Your ref
Our ref TL /3/2012/1101
Date 28th February 2013

Planning application no: 3/2012/1101

Proposal: Demolition of existing dwelling and redevelopment of the site for residential use including 16 homes.

Location: The Whins, Whins Lane, Read BB12 7QY.

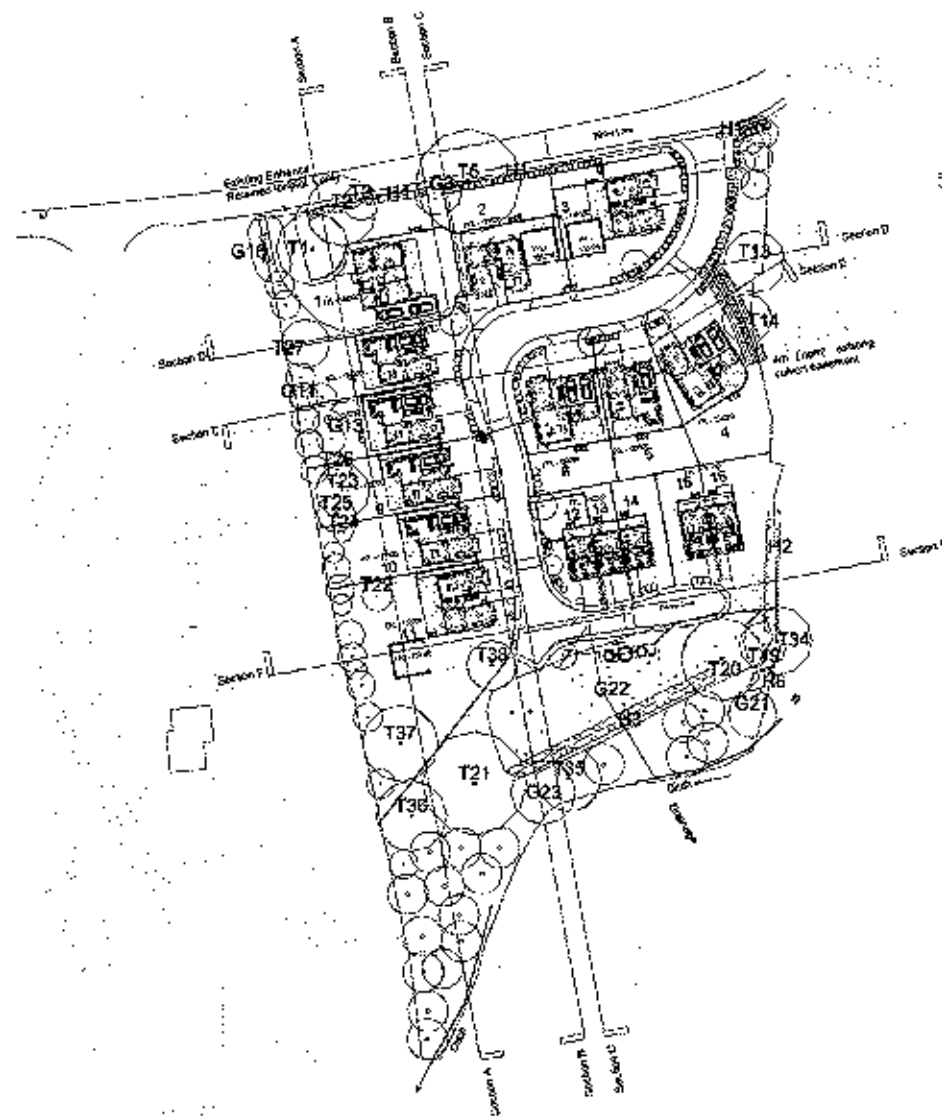
Plots 5, 7 – 10, 12 and 13 appear to be short of one parking space, making a deficiency of 7 parking spaces across the whole development. Due to the location of this development on a narrow country lane, and due to the limited available space on the estate road for parking, I would ask that additional parking spaces are provided on the seven plots mentioned.

Site Layout

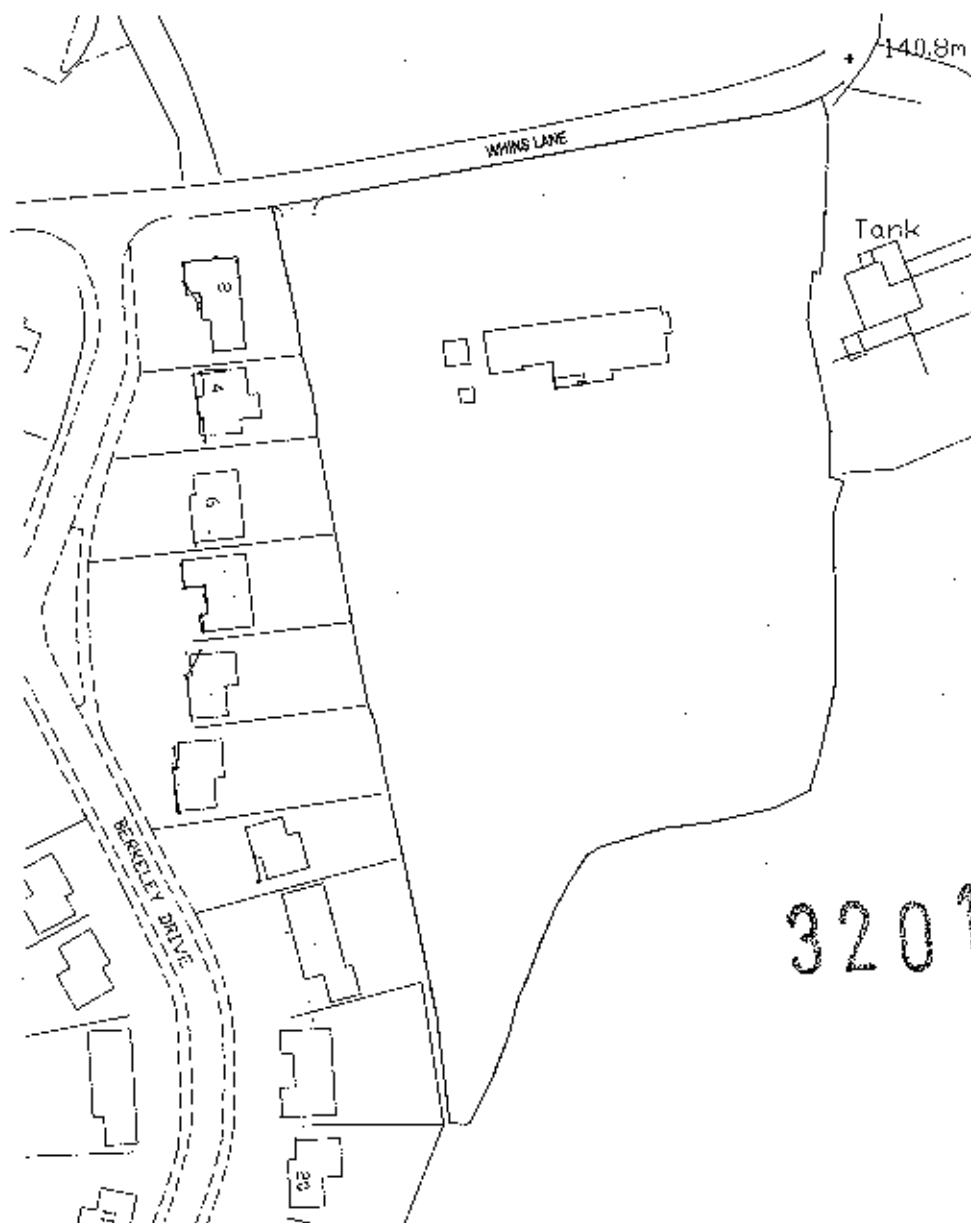
1.1 The estate road width is 5.5m from the access on to Whins Lane to the second bend in the road. From about half way around this second bend, the carriageway reduces from 5.5m to 4.5m. It would be preferable to reduce the width of the carriageway on a straight length of road rather than on a fairly severe bend. Where ever the width reduction occurs, the transition should be carefully designed so that it is obvious where the reduction in carriageway width occurs. Also there should be a feature in the carriageway alerting drivers to the reduction in width. This could be a change in surfacing texture / colour or a rumble strip (although rumble strips tend to result in complaints from nearby residents because of the noise they make).

1.2 As suggested above, the bend in the estate road at plot 7 is severe, and I would ask that a greater radius along the carriageway centre line is used – say a 20m radius. The severity of the curve does present issues for forward visibility along this road. Assuming a 20 mph speed limit here, a forward visibility of 25m is desirable (see Manual for Streets section 7.8). The building proposed and the garden on plot 6 restricts this forward visibility,

and the layout should be altered here. Among other issues, the reduction in width of the carriageway is partially obscured from view.

1.3 It is not clear what the developer's intentions are as far as the extent of the future adopted highway is concerned. It appears that the adopted highway is proposed to end at plot 8, after which the road would be unadopted. A shared carriageway as shown beyond plot 8 is acceptable and this would be acceptable for adoption on condition that 1.8m wide service strips are provided on both sides of the carriageway. If the shared carriageway section of road is not adopted, then a turning head will be required at the end of the adopted section of road near to plot 8.
